From: Ian Stocks [REDACTED] **On Behalf Of** FRS Water and Access
Sent: 03 March 2021 10:22
To: Planning.Responses <Planning.Responses@arun.gov.uk>
Subject: Hydrant condition - BN/17/21/PL The Cottage Highground Lane Barnham PO22 0BT

HYDRANT CONDITION CONSULTATION WITH PLANNING AUTHORITY

Planning Ref: BN/17/21/PL

Address: The Cottage, Highground Lane, Barnham, PO22 0BT

SITE / BLOCK PLAN 1:500

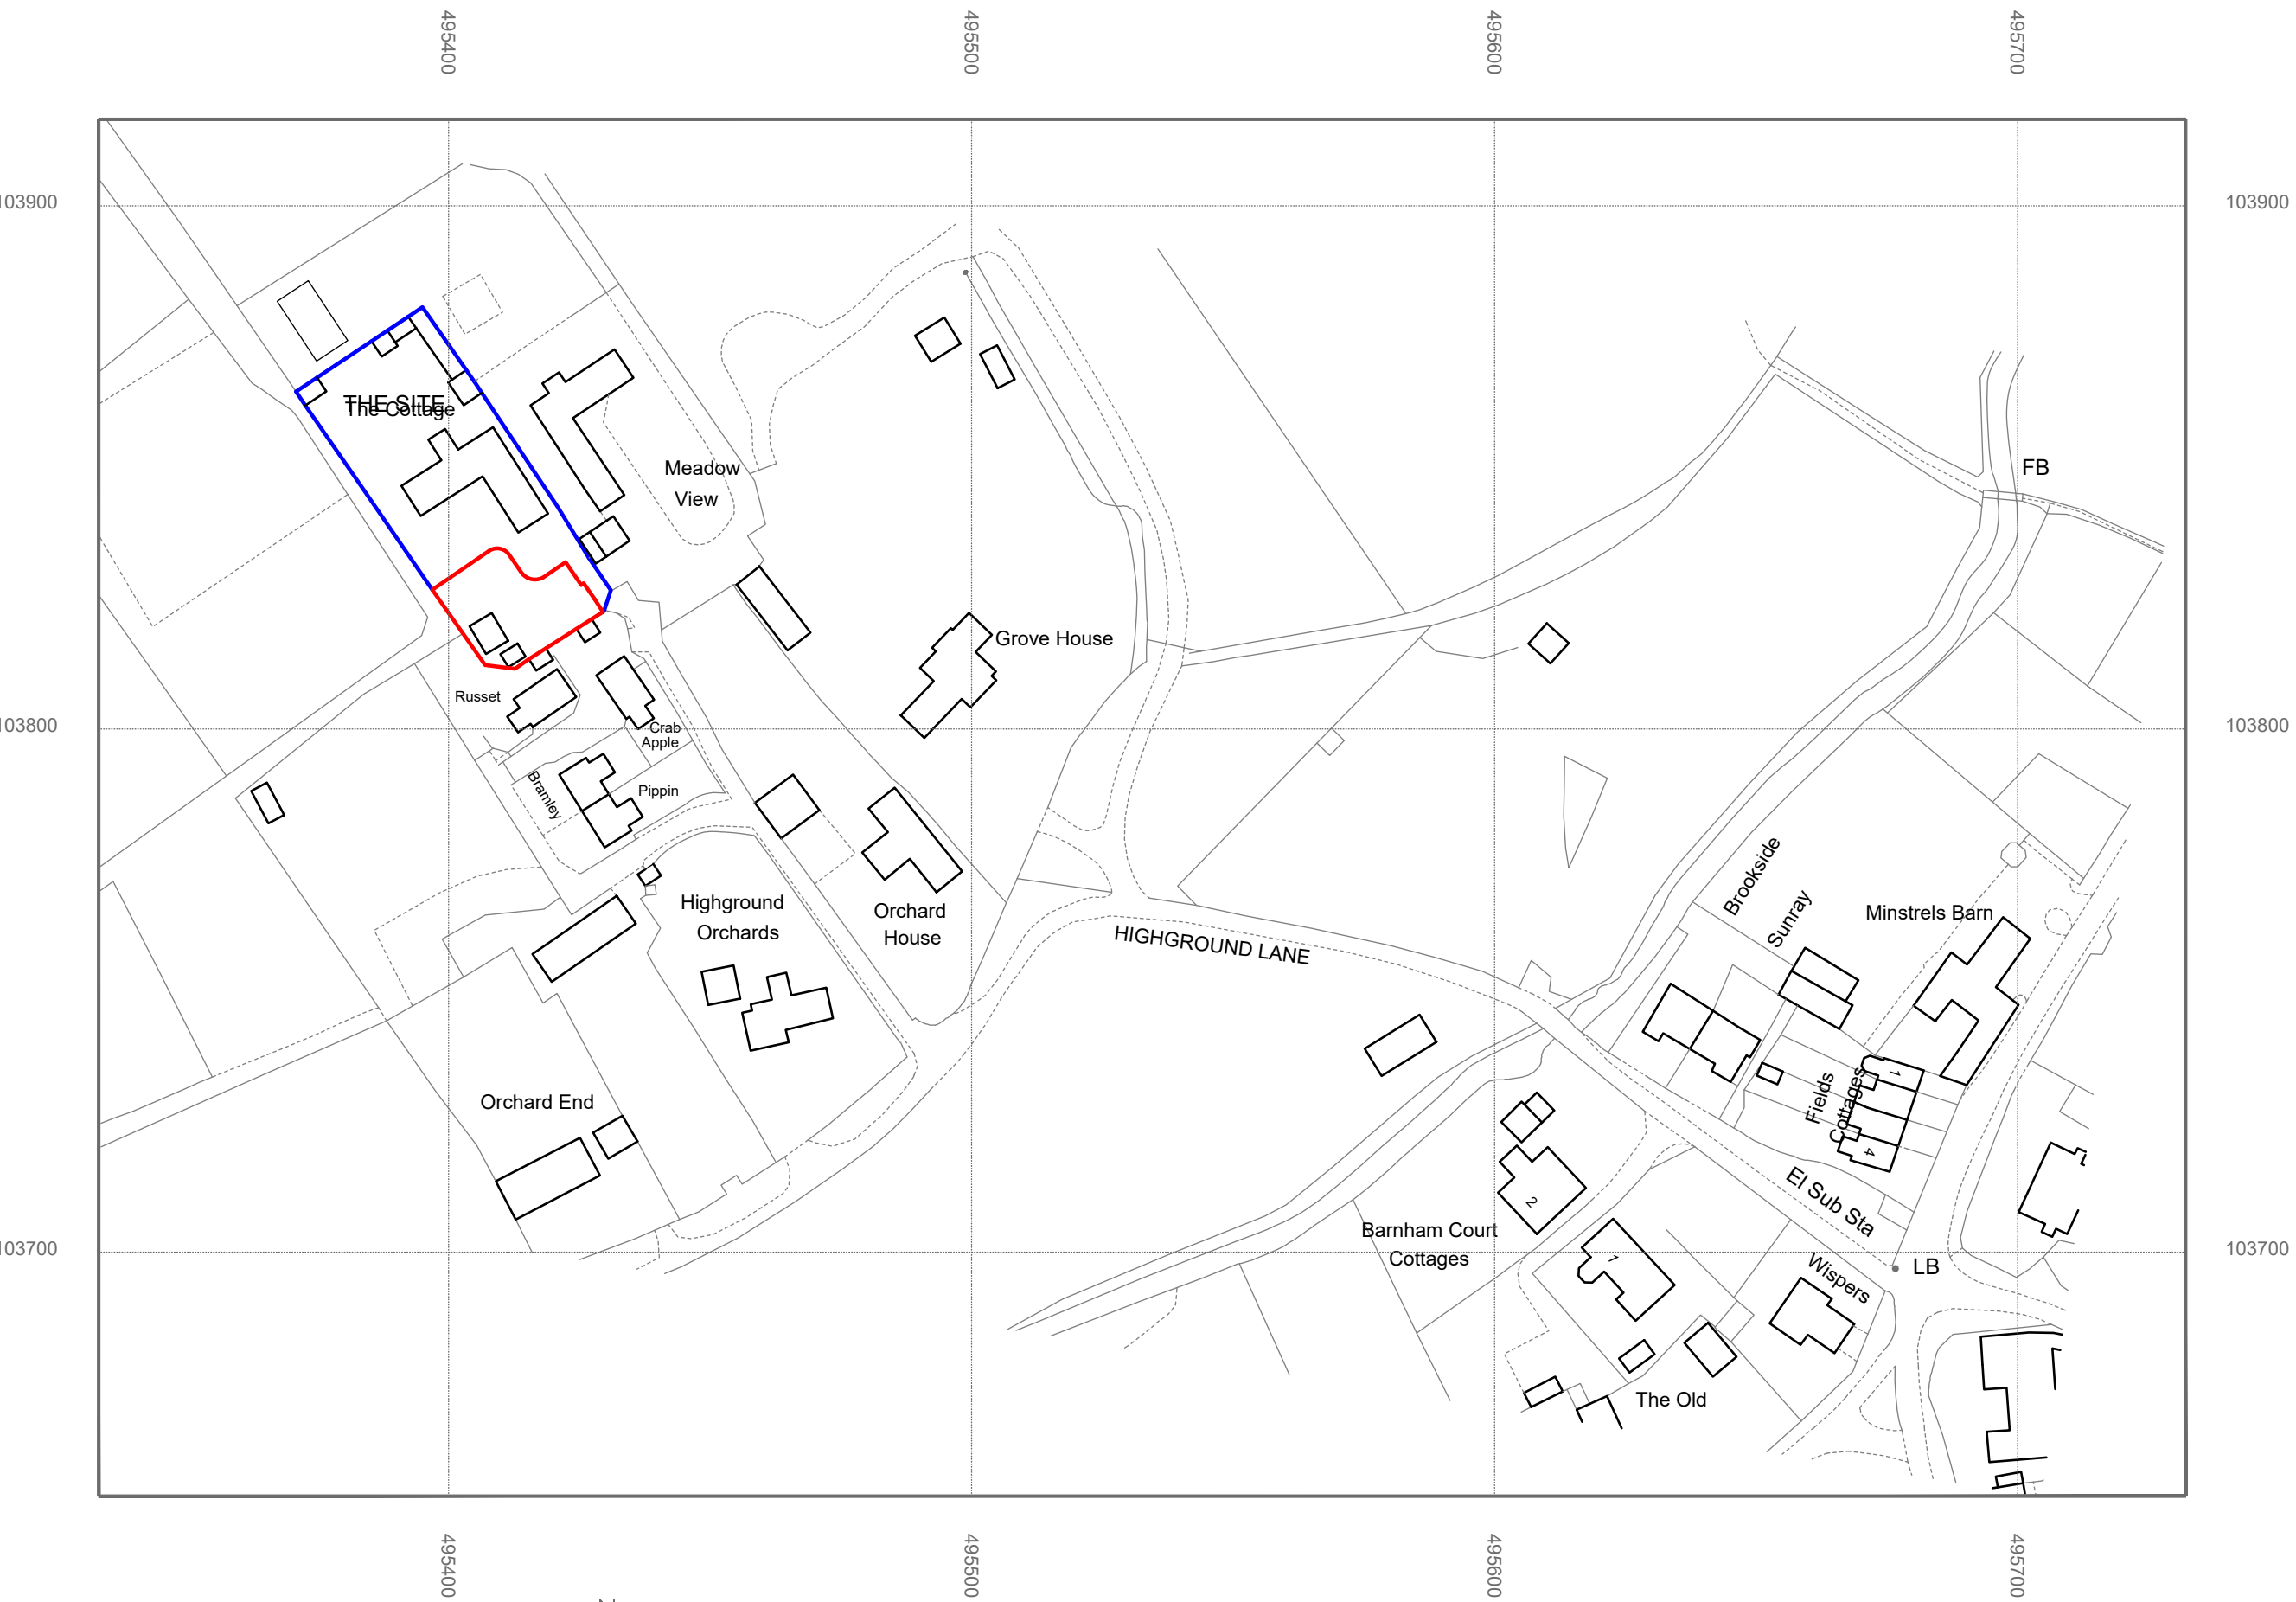
Please find attached a planning condition for application no. BN/17/21/PL for the requirement of an additional fire hydrant. Currently the nearest Hydrant to these proposed properties is 350 metres away. The supply of water for firefighting for a domestic premises should be within 175 metres.

Evidence will also be required that Fire Service vehicle access meets with the requirements identified in Approved Document B Volume 1 2019 Edition: B5 Section 13, including Table 13.1 and diagram 13.1.

- 1) Prior to the commencement of the development details showing the proposed location of [1] one fire hydrant or stored water supply (in accordance with the West Sussex Fire and Rescue Guidance Notes) shall be submitted to and approved in writing by the Local Planning Authority in consultation with West Sussex County Council's Fire and Rescue Service. These approvals shall not be unreasonably withheld or delayed.
- 2) Prior to the first occupation of any dwelling/unit forming part of the proposed development that they will at their own expense install the fire hydrant in the approved location to BS 750 standards or stored water supply and arrange for their connection to a water supply which is appropriate in terms of both pressure and volume for the purposes of firefighting.
